CITY OF PORTLAND, MAINE

ZONING BOARD OF APPEALS

RE: 5 Bramblewood Drive
CBL: 377 E006
ZONE: R-3

DECISION

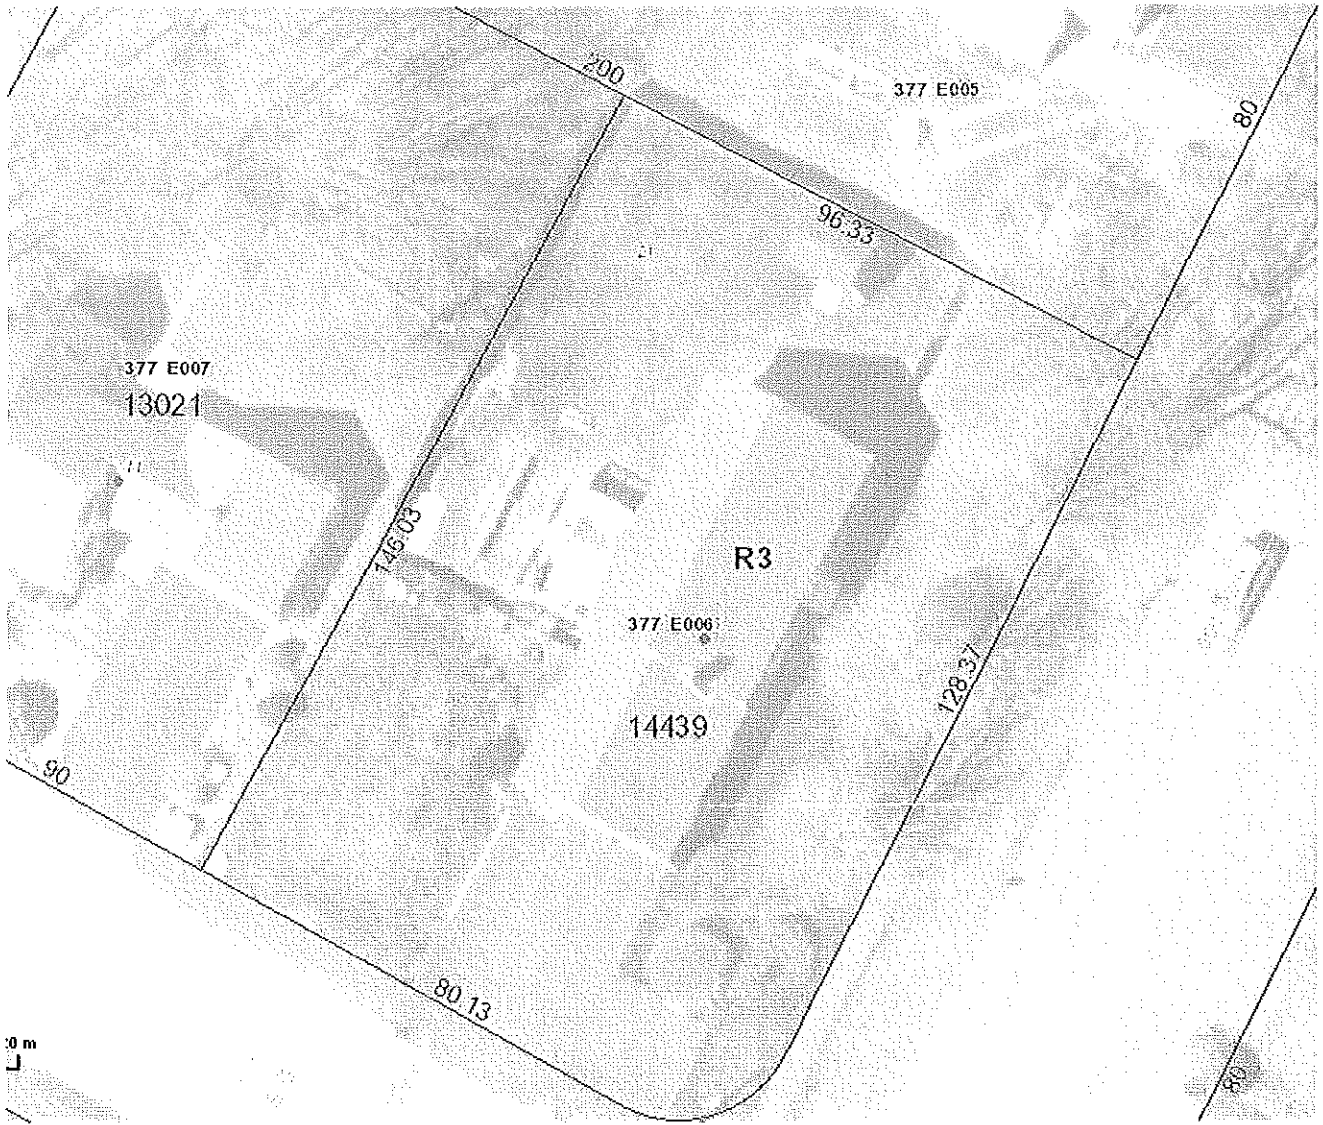
Gina Kostopoulos applied for a permit (#2012-10-5099) to add a daycare as a home occupation to the use of her property as a single family home. Part of the application included floor plans for both floors of her house. The floor plans showed a kitchen located on the main floor of the house and a kitchen located in the lower level in the proposed area for the daycare. I spoke to Ms. Kostopoulos on October 2, 2012 asking her about the second kitchen. She told me that a previous owner had put it in and that it had been used as part of a daycare that had been operated in the house previously. I informed Ms. Kostopoulos that two kitchens were not allowed in a single family home.

I wrote a letter on October 11, 2012 explaining why the second kitchen needed to be removed. Section 14-47 of the ordinance defines a dwelling unit as "one (1) or more rooms with private bath and kitchen facilities comprising an independent self-contained unit". The floor plans show that the lower level has a living room, dining area, bedroom, kitchen facilities and a private bath. The property is located in the R-3 residential zone. Section 14-86 states that the purpose of the zone is "to provide for medium-density residential development characterized by single family homes on individual lots". When a second kitchen is added to a single family home, by definition a second unit is created. By having one kitchen in a building it guarantees that the use will remain a single family home and not allow for an illegal dwelling unit to be created. There is a process to allow an accessory dwelling unit as a conditional use appeal.

In reviewing your application to add a daycare as a home occupation, I noticed on your floor plans that there are two kitchens in the home, one on the main floor and one on the lower level. Our records show the legal use of the property as a single family home or a single dwelling unit. Section 14-47 defines a dwelling unit as “one (1) or more rooms with private bath and kitchen facilities comprising an independent self-contained dwelling unit”. In other words a dwelling unit has one kitchen. A second kitchen in a building changes the use of the building from one dwelling unit to two dwelling units. I have researched our records, and there is no record of a second kitchen being added to the building. Since the use of the building is one dwelling unit, the second kitchen is illegal and needs to be removed.

ordinance defines kitchen facilities as “facilities used for the preparation of meals, including refrigerators and devices used for the cooking and preparation of food”. In one of our telephone conversations you said that there was a full sized refrigerator and a stove in the lower level. These would have to be removed along with any sink and other device used for cooking and preparation of food.

The unit is self-contained: there is only one utility meter, no separate climate control, and no separation between upstairs and down. ~~unit~~. The second kitchen is for the name occupation and not for use as a separate dwelling unit. A second kitchen does not automatically trigger a second unit.
